From: Contact Centre (CRM) <contact@ribblevalley.gov.uk>
Sent: 02 July 2022 19:45
To: Planning
Subject: Planning Application Comments - 3/2022/0532 FS-Case-434003183

Planning Application Reference No.: 3/2022/0532

Address of Development: 39 The Rydings
Langho
BB6 8BQ

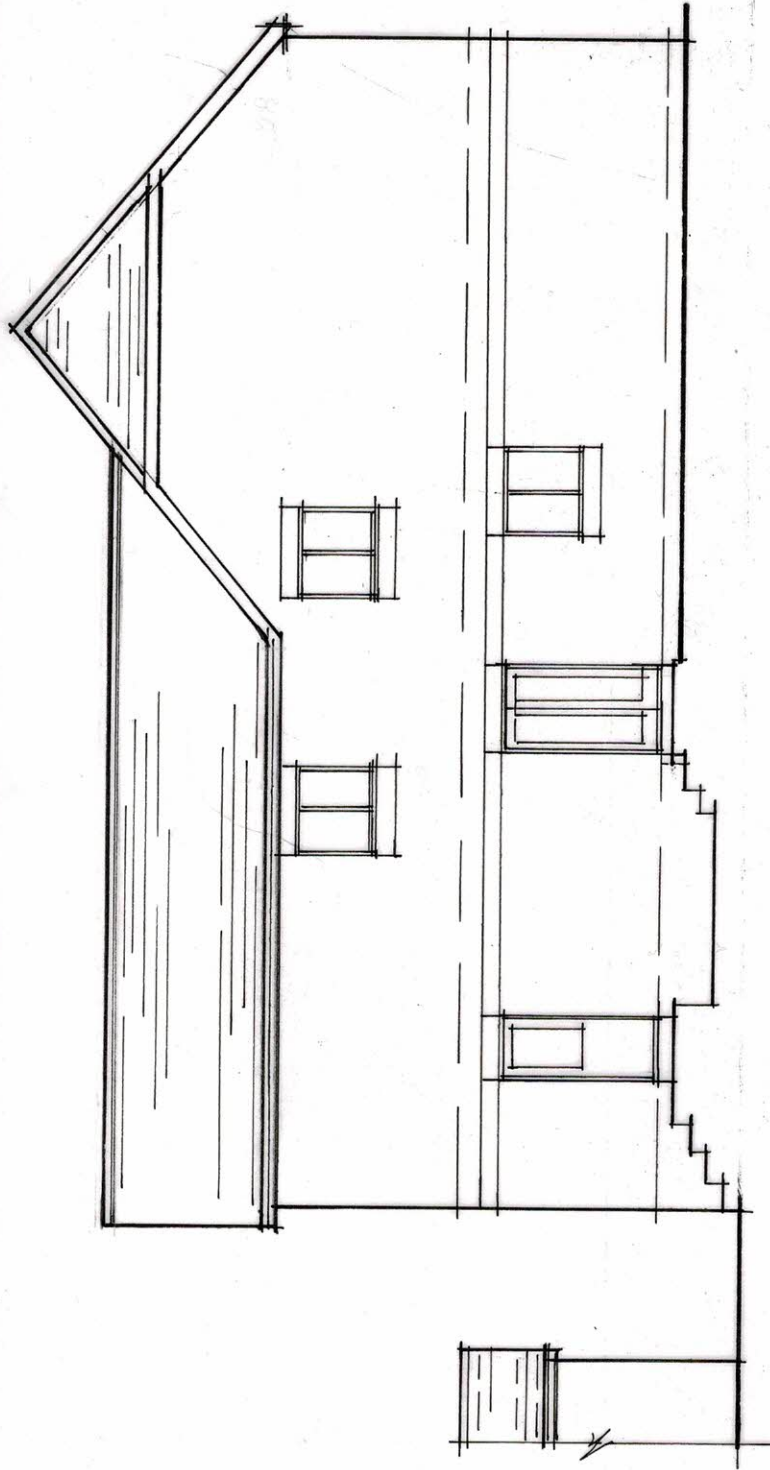
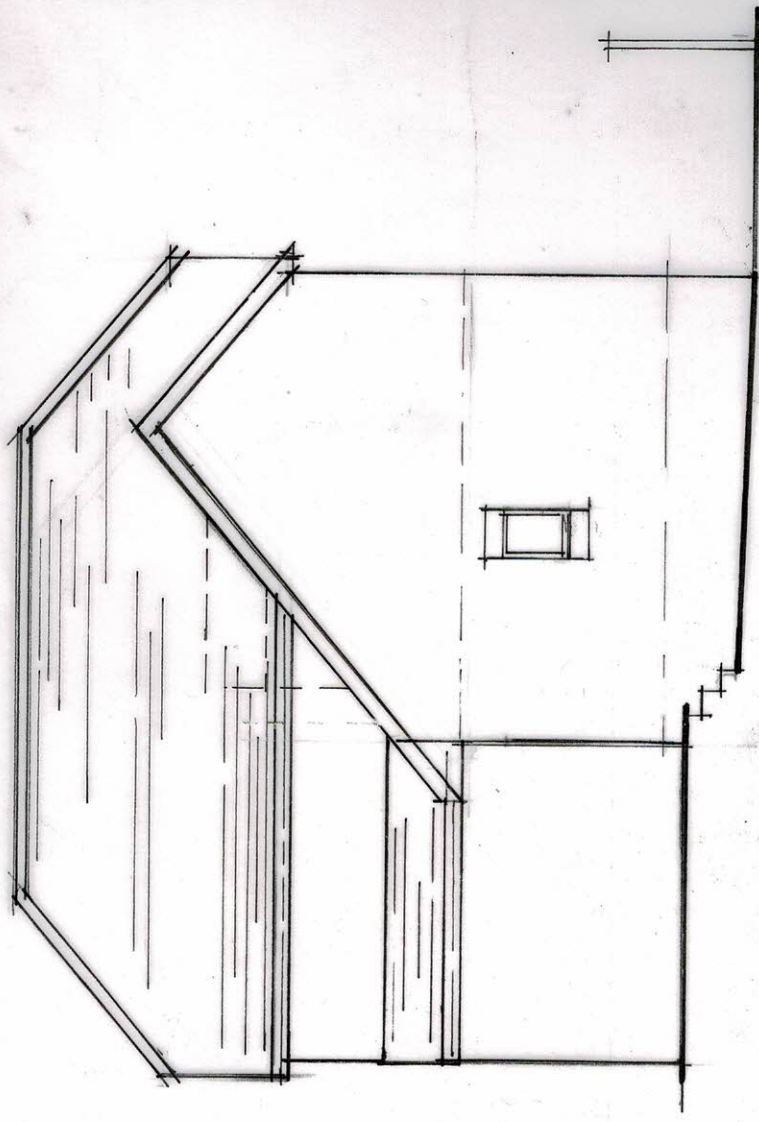
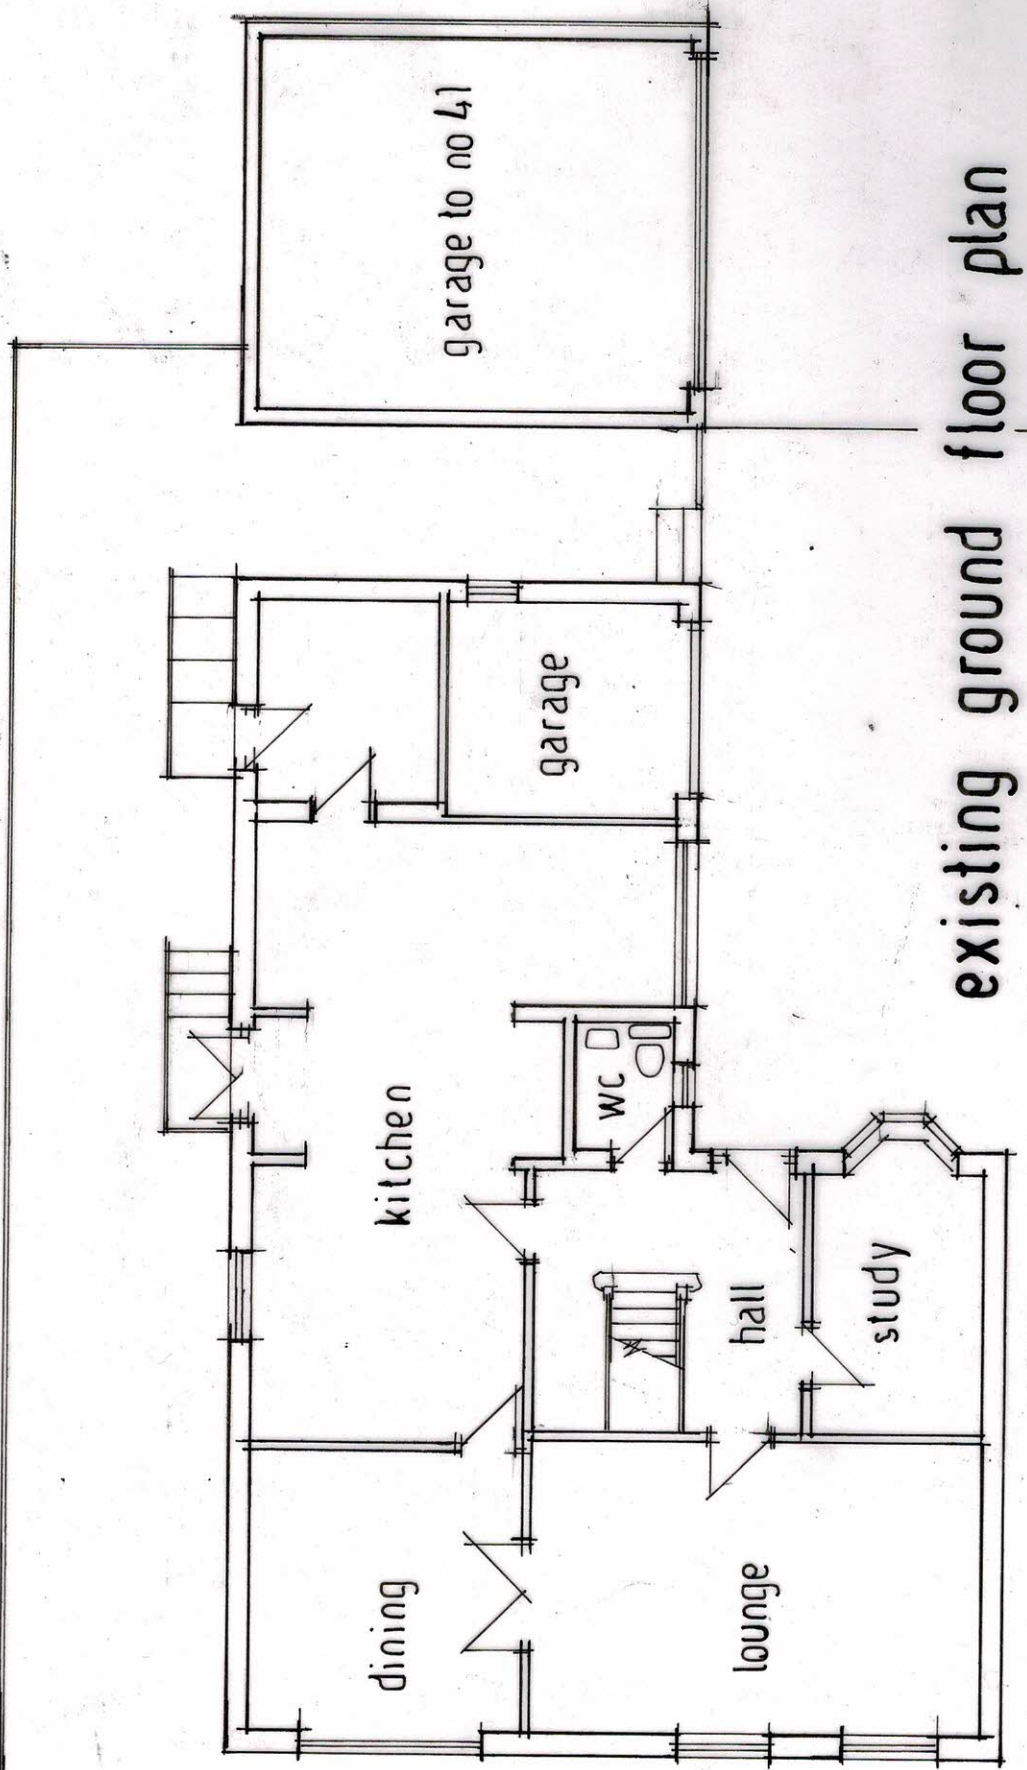
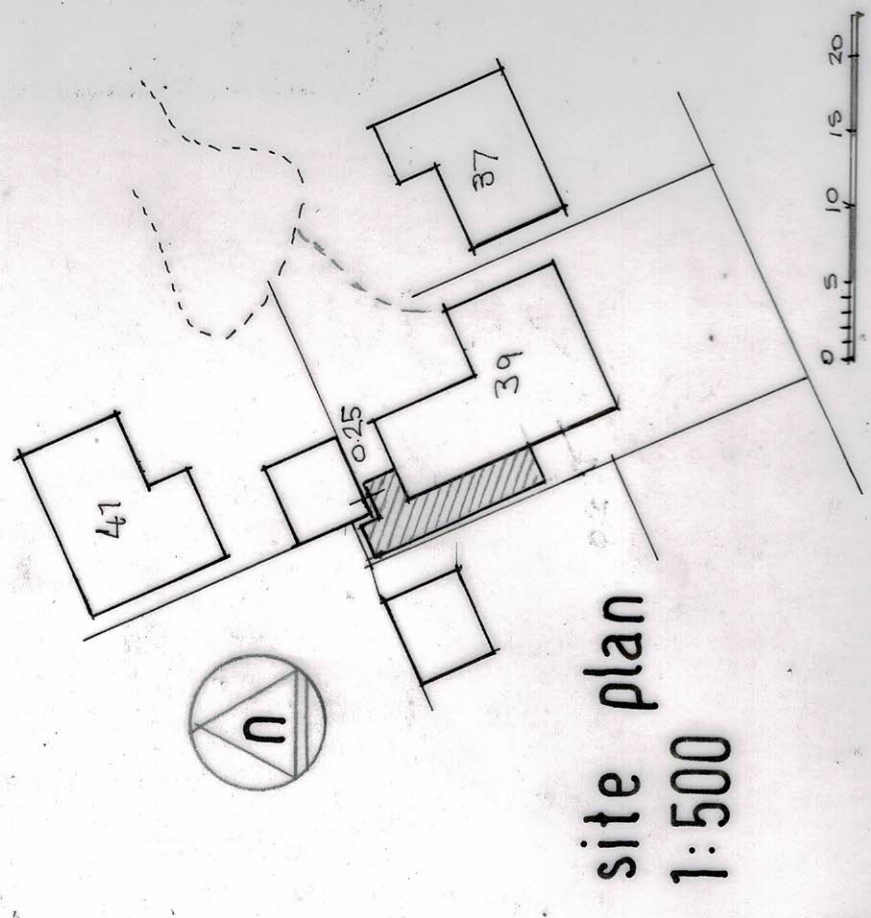
Comments: The proposed extension is a significant development consisting of approximately 92m³ rear extension and 37m³ side extension. The total width is more than half the width of the existing building. It will be built within 2m of existing boundaries to 3 properties and have a maximum height of 4.5m.

- a) cramming in an rear extension all the way to the western boundary fence to [REDACTED] The Rydings and
- b) a side extension taking all the space between the garage to [REDACTED] and the northern boundary fence to [REDACTED] the Rydings.

The plans do not show the conservatory extension that has already been constructed in the garden and this proposal will take up a significant proportion of the available land surrounding the property.

The roof of the proposed extension will be higher than the existing roofline [REDACTED] The slope of the proposed store roof will contrast significantly with that of the adjoining garage especially when it is built immediately adjoining. [REDACTED] is slightly lower in elevation it will be faced with a 5m high brick wall which will tower up to 3m above the existing fence.

roof plan 1 : 100

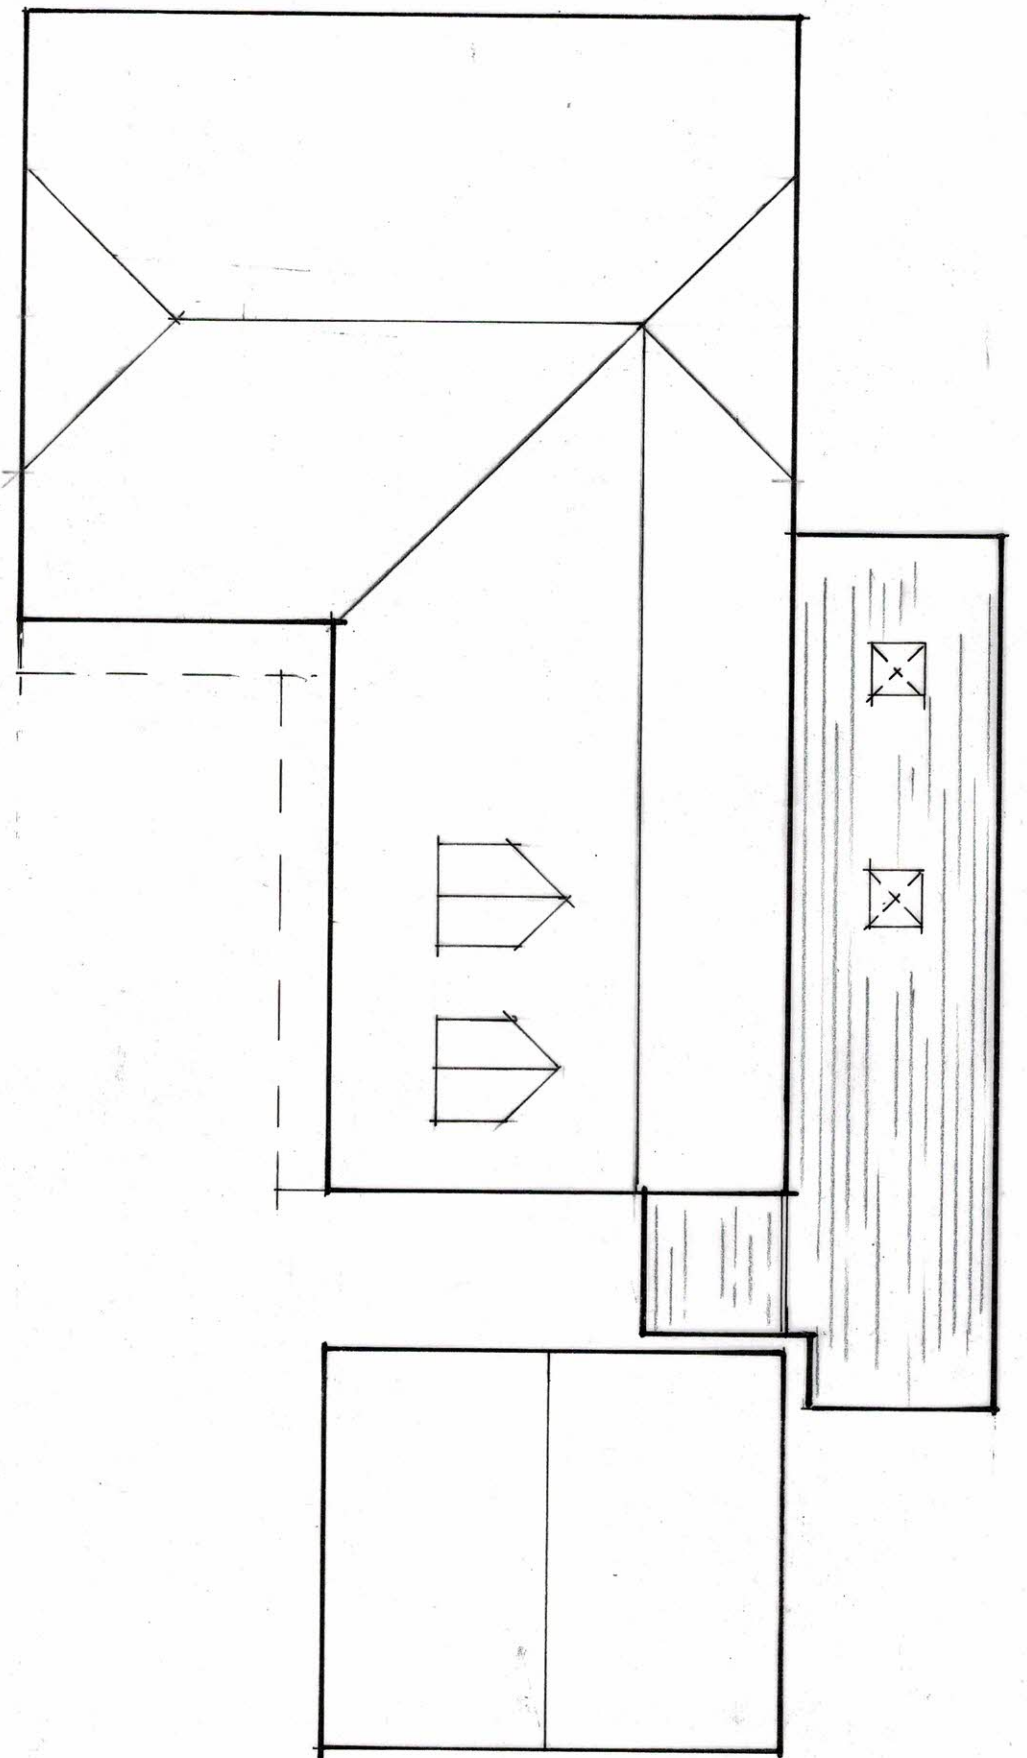
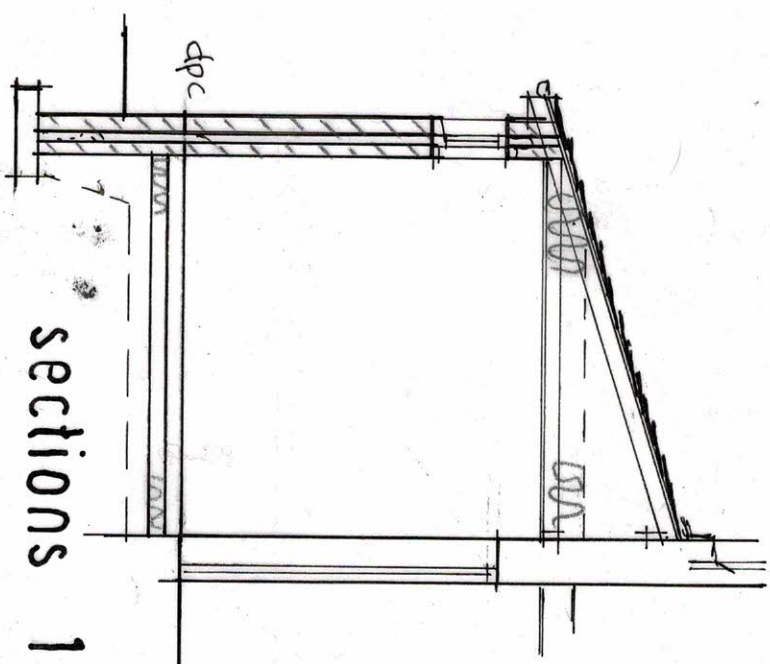
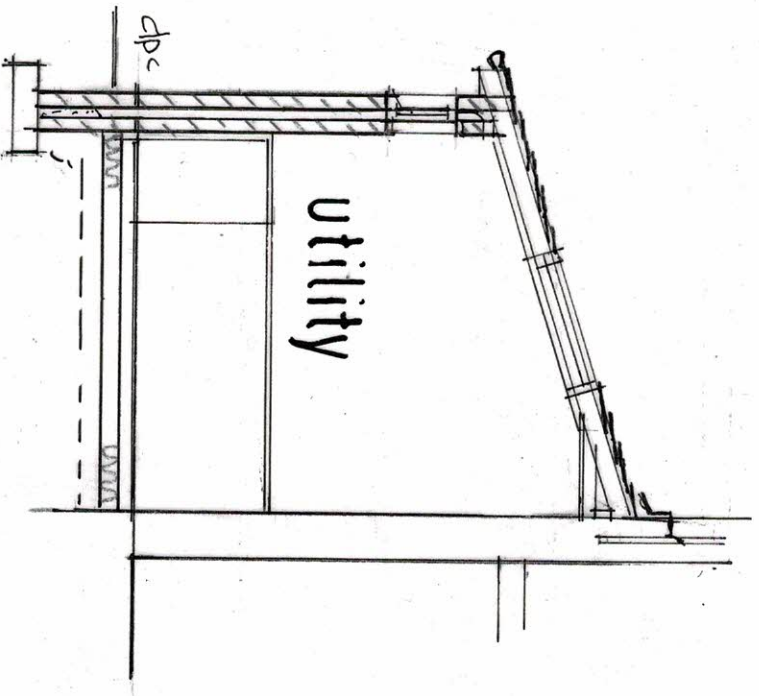
A key consideration for any project is the impact on future maintenance. No mention is made in the proposal for rain water goods and dealing with water from the roof structures. Currently one of the downspouts to the existing gutter at the [REDACTED] is blocked with weeds growing out. This leads to water cascading onto the existing hard flagged surface and ponding of water to the [REDACTED] where the ground level is a foot or more lower. This standing water issue is made worse by the gutters to the [REDACTED] also getting blocked and surcharging.
